Our Ref: FG/4/20/NMA

**Section 96A of the Town & Country Planning Act 1990 (as amended)
Town and Country Planning (Development Management Procedure) (England) Order 2015 (as amended) - Article 10**

Non-material amendment for various changes (1 - 15) following approval of FG/122/17/HH
5 Sea Drive Pebble Patch Ferring BN12 5HD

SIDE (EAST) ELEVATION

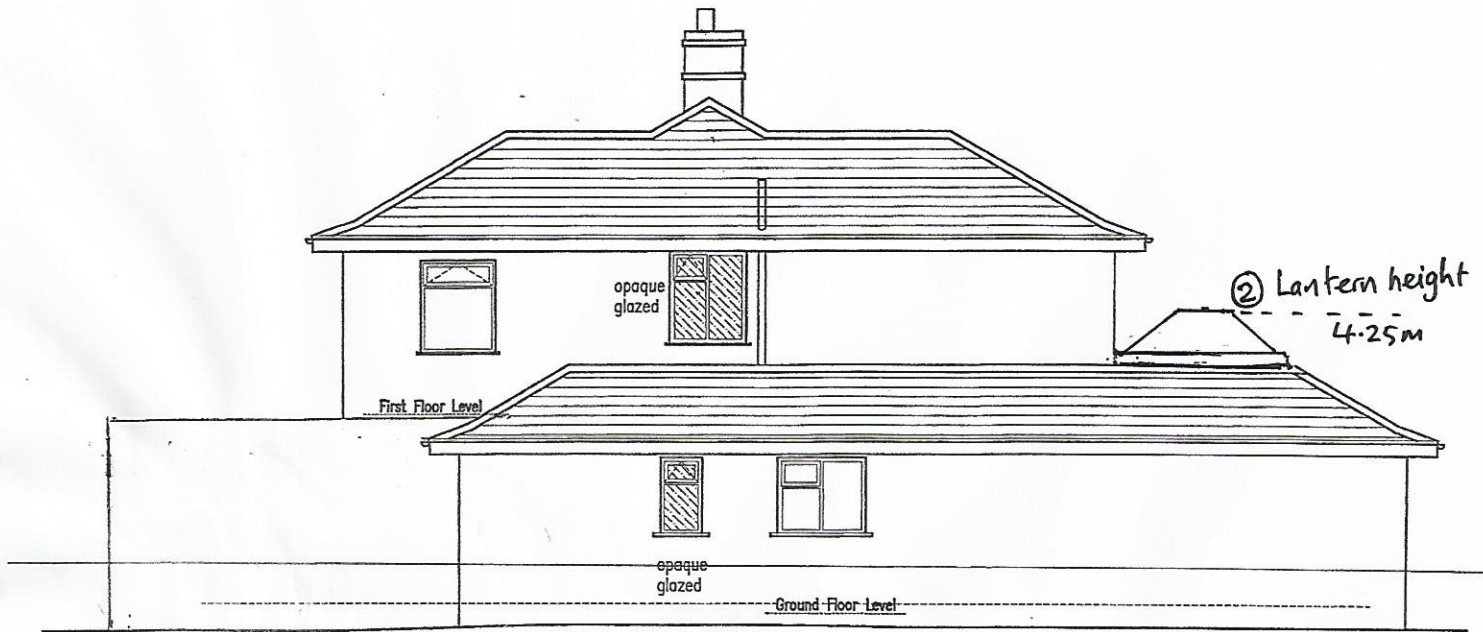
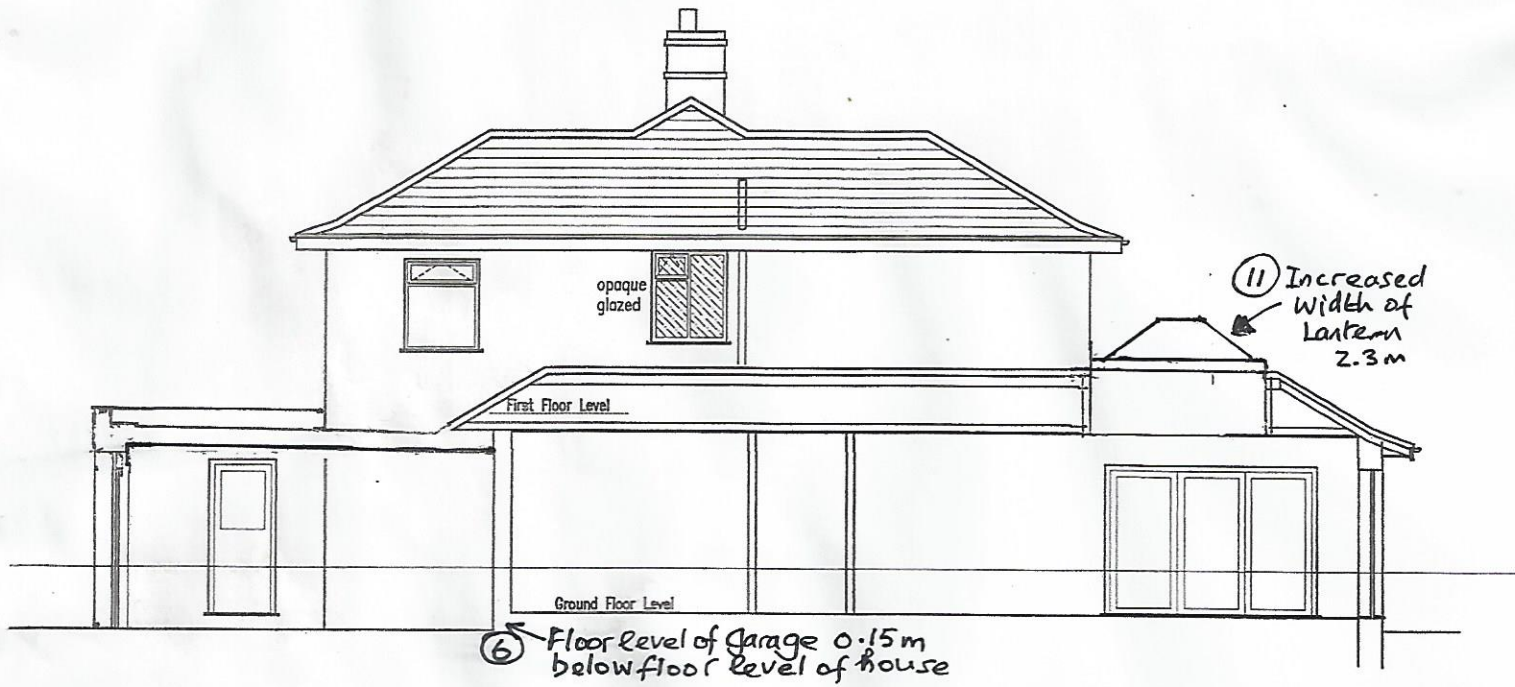
1. Roof height of side extension at front & rear
2. Lantern height
3. Forward projection of garage
4. Height of garage west elevation
5. Height of garage east elevation
6. Floor level of garage below floor level of house
7. Distance of side extension to eastern boundary at the rear
8. Distance of side extension to eastern boundary at the front
9. Garage distance to eastern boundary
10. Width of garage
11. Increased dimensions of the lantern window located within the ground floor extension
12. Dining area window to the rear to indicate 3 No. panes within the opening
13. First floor rear bedroom window
14. New roof opening in the front garage extension

15. Window instead of door to front of utility room

Drawing numbers Side (East) Elevation and Section B;B Dwg No CH762/008 Rev AW ; Front (South), Side (West) and Rear (North) Elevation CH762/003 Rev AW; Ground Floor Plan Dwg CH762/005 Rev AW; Ground Floor Plan Dwg No CH762/005 Rev AW and Roof Plan CH762/09D Rev AW have therefore become the approved elevation, Ground Floor and roof plans for planning permission FG/122/17/HH.
